**Application Reference:** 2026/0300

**Site Address:** 27 Quarry Street, Cudworth, Barnsley S75 8LS

**Introduction:** This application seeks full planning permission for a 2 storey side and rear extensions to dwelling

**P.5**

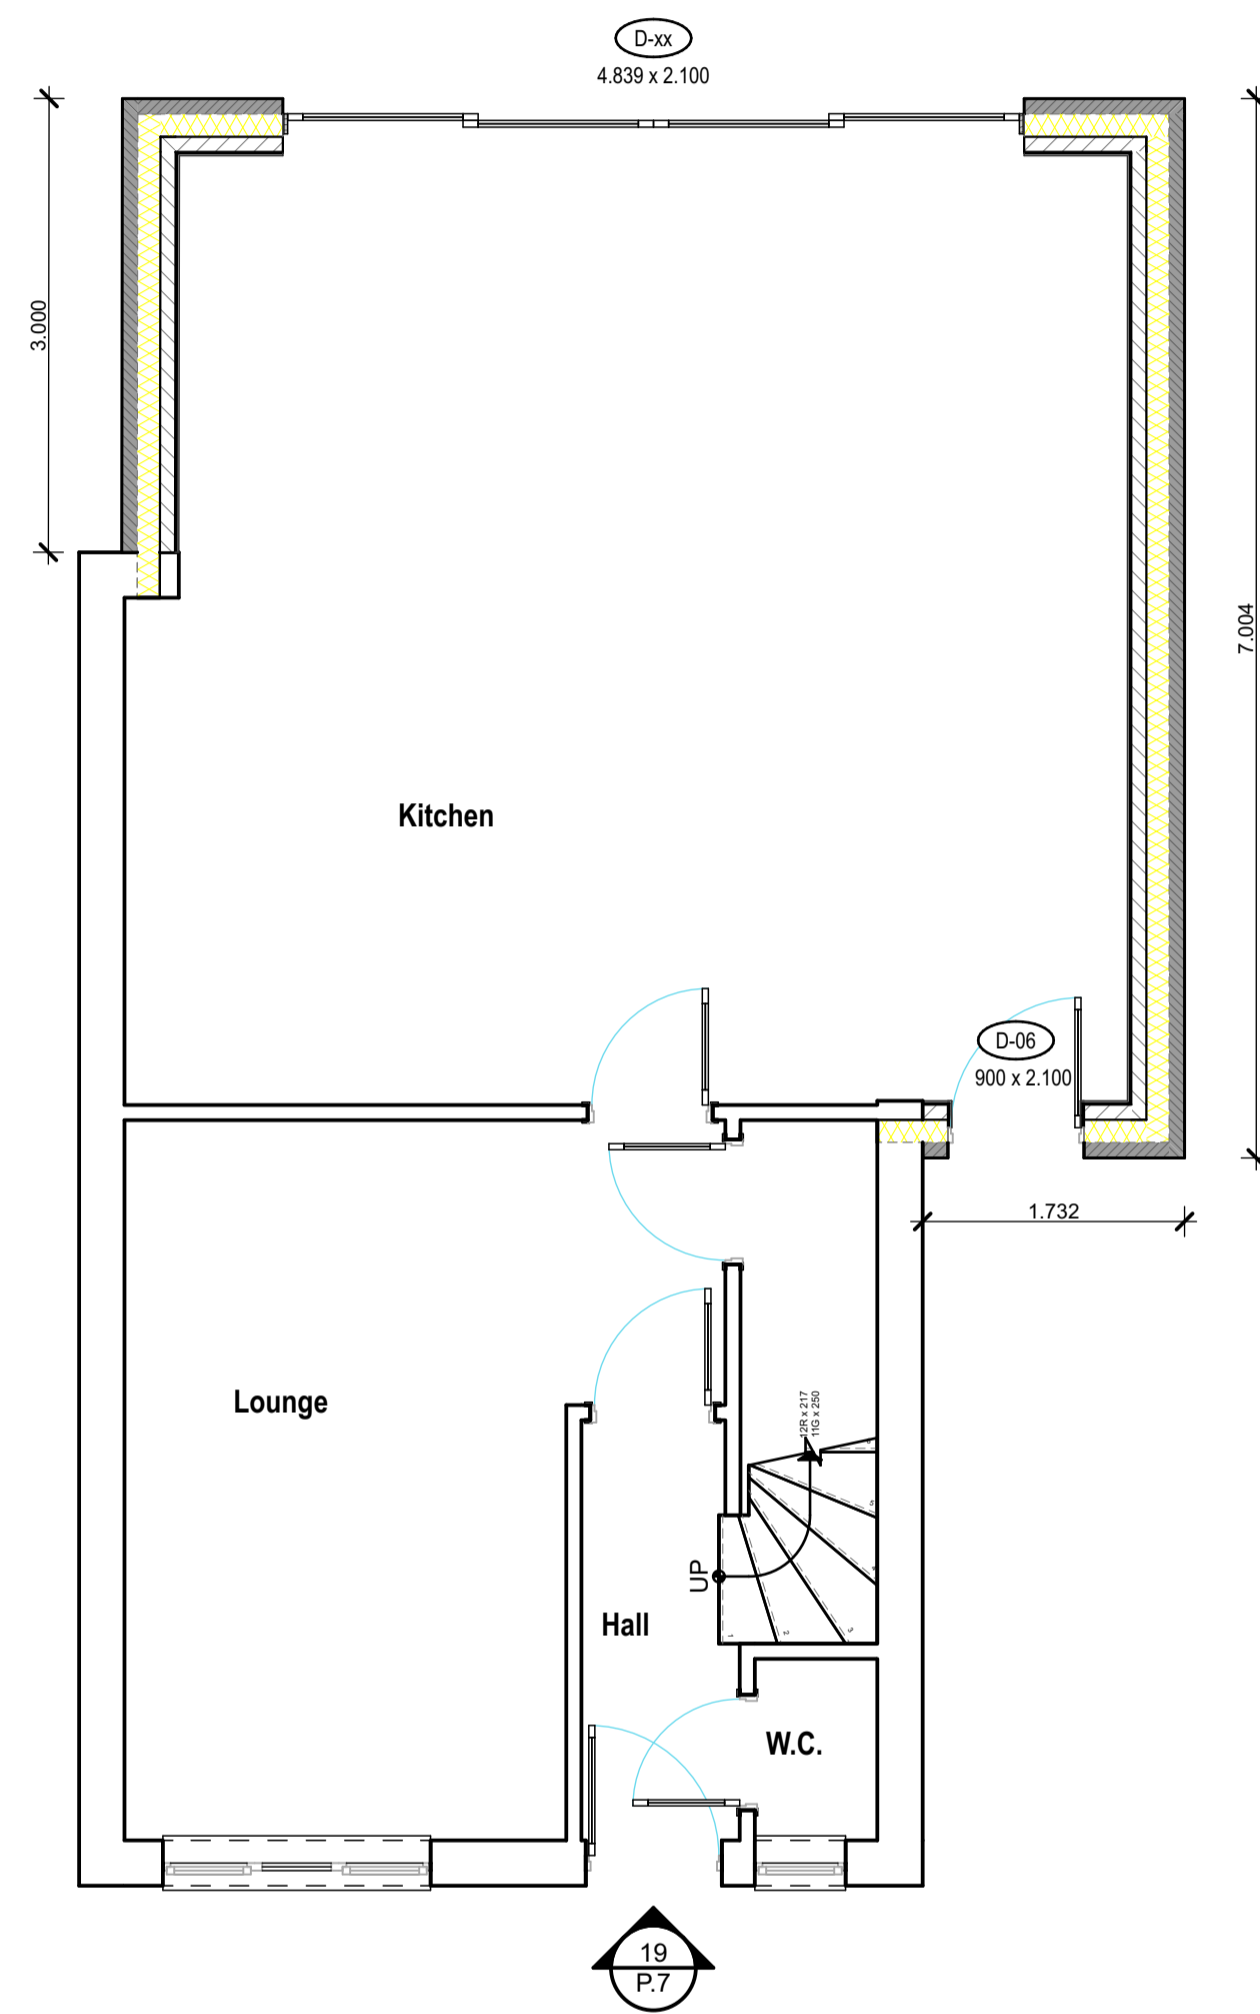
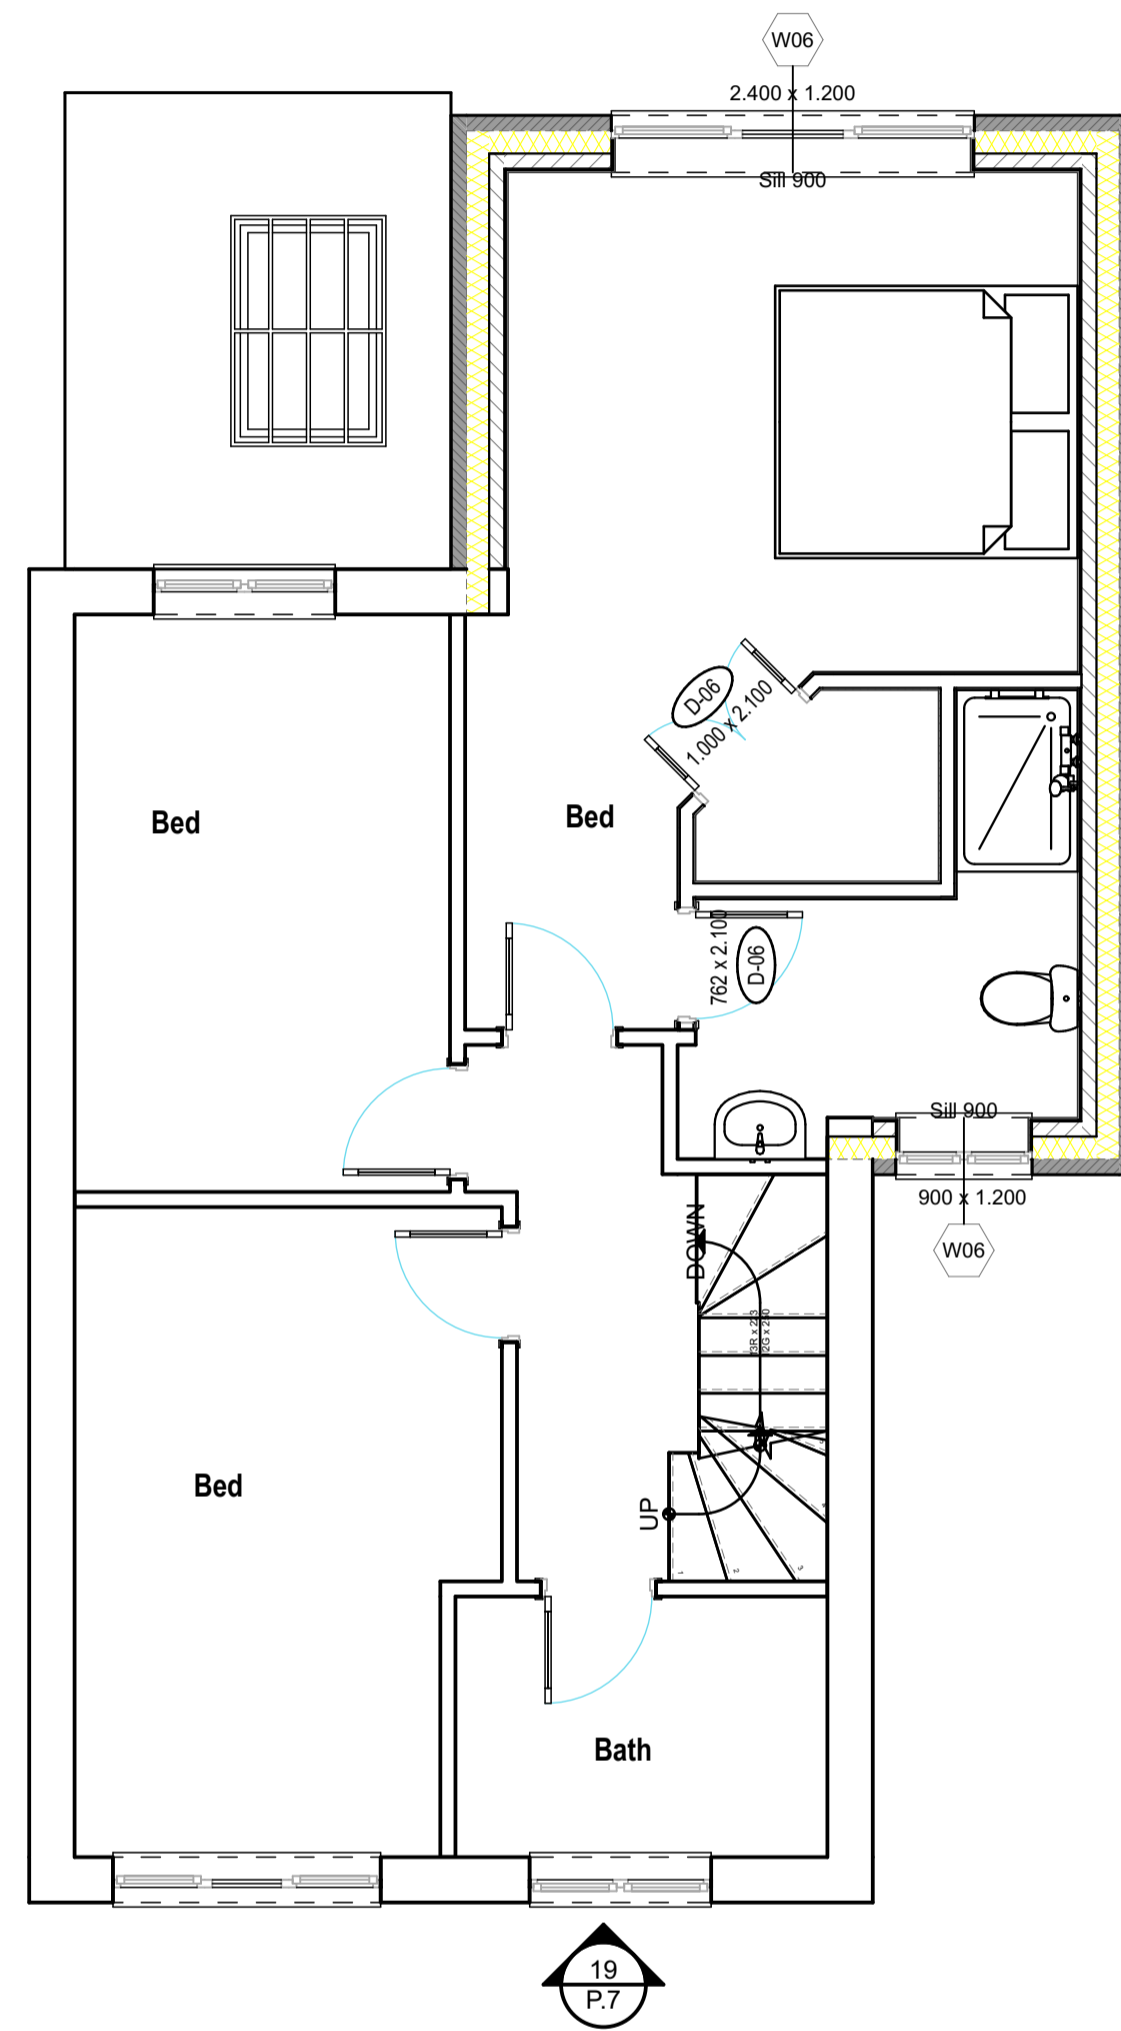
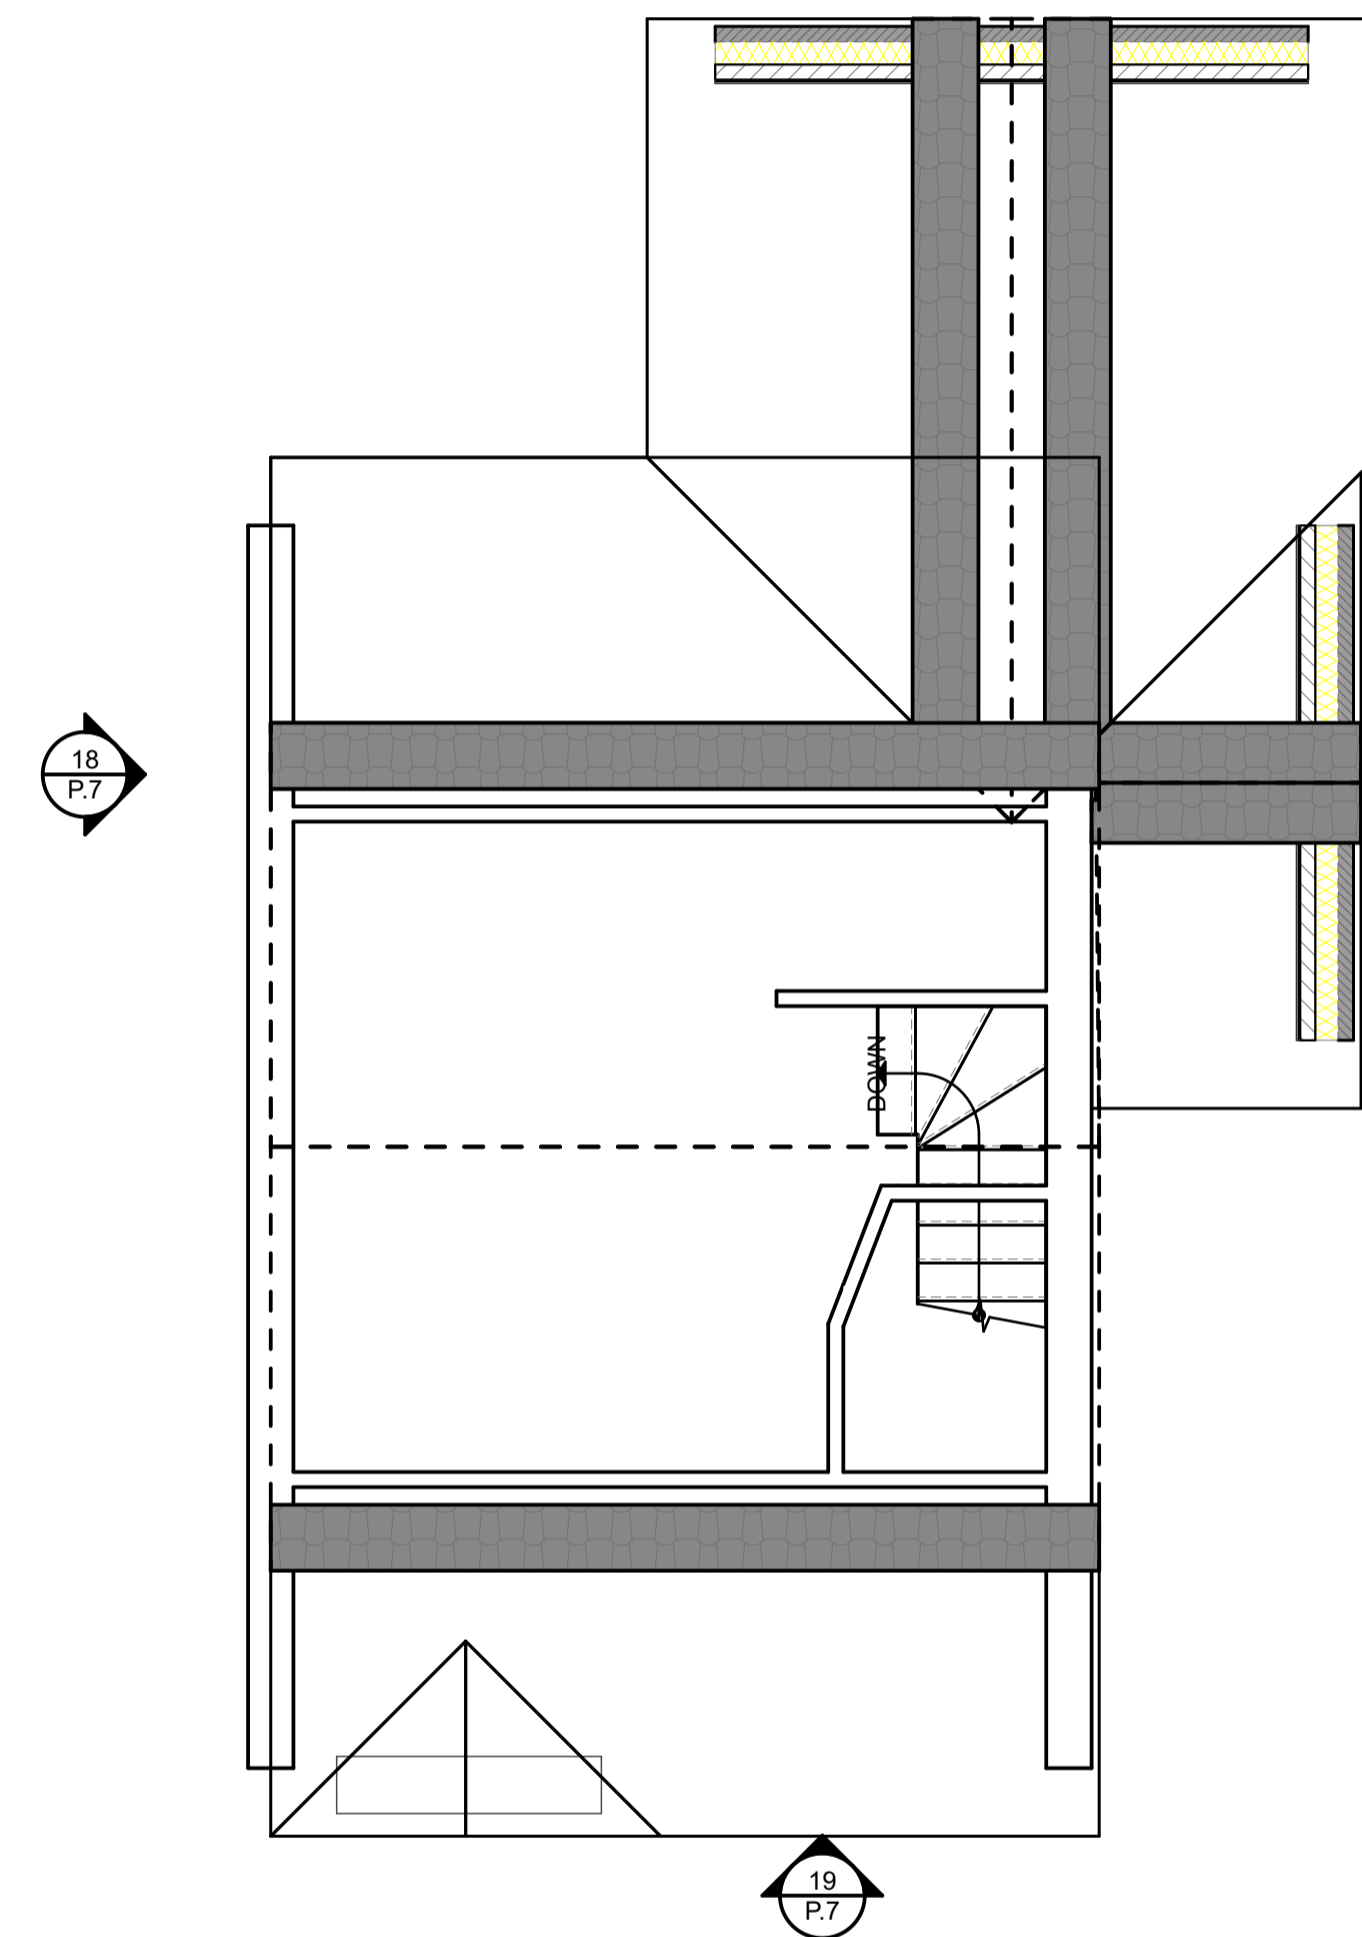
The proposed extension in terms of relationship with the house would be of an acceptable scale, featuring a proposed footprint increase of approximately 28 sqm to an existing footprint of 49 sqm. On the first floor, whilst the original footprint matches the ground floor below, a smaller increase of approximately 25.5 sqm is proposed.

Approximate measurements for the rear aspect of the extension are a 3m projection from the rear elevation of the house, and a 7.02m width incorporating the 1.73m width of the side extension. The first-floor aspect of the two-story extension is set in by 2.5m from the side boundary with the attached neighbouring dwelling, giving a first-floor width of 4.52m, again incorporating the 1.73m of the side extension. Within the 2.5m setback from the side boundary, the roof of the ground floor extension overhangs by 0.15m (15cm), and there is a central rooflight, with height of about 20cm above that of the flat roof.

The existing two first-floor elevation windows have distance of 9m to the rear boundary treatment, with an extra buffer of 1m created by the retaining wall. Below this wall sits the final 10m section of No 19 Belle Green's 21m rear garden. Beyond this rear garden is over 35m of public highway, dwelling's driveways and front gardens. With the extension projecting 3m from the rear elevation of the dwelling, the proposed windows would feature a reduced distance to the rear boundary wall of 6m or 7m including the boundary wall itself.

The remaining dwelling which may be affected is the attached neighbouring dwelling of No 25 Quarry Street. Due to the design of the proposed rear aspect of the extension, the impact of the proposal, particularly the first-floor aspect of the rear extension would be minimised. Unlike the ground floor aspect of the extension which would be constructed up to, or close to the boundary with No 25, the first-floor aspect is set in by 2.5m from the shared boundary. With no side elevation windows proposed, there would be no concern over privacy but despite the design, there may still
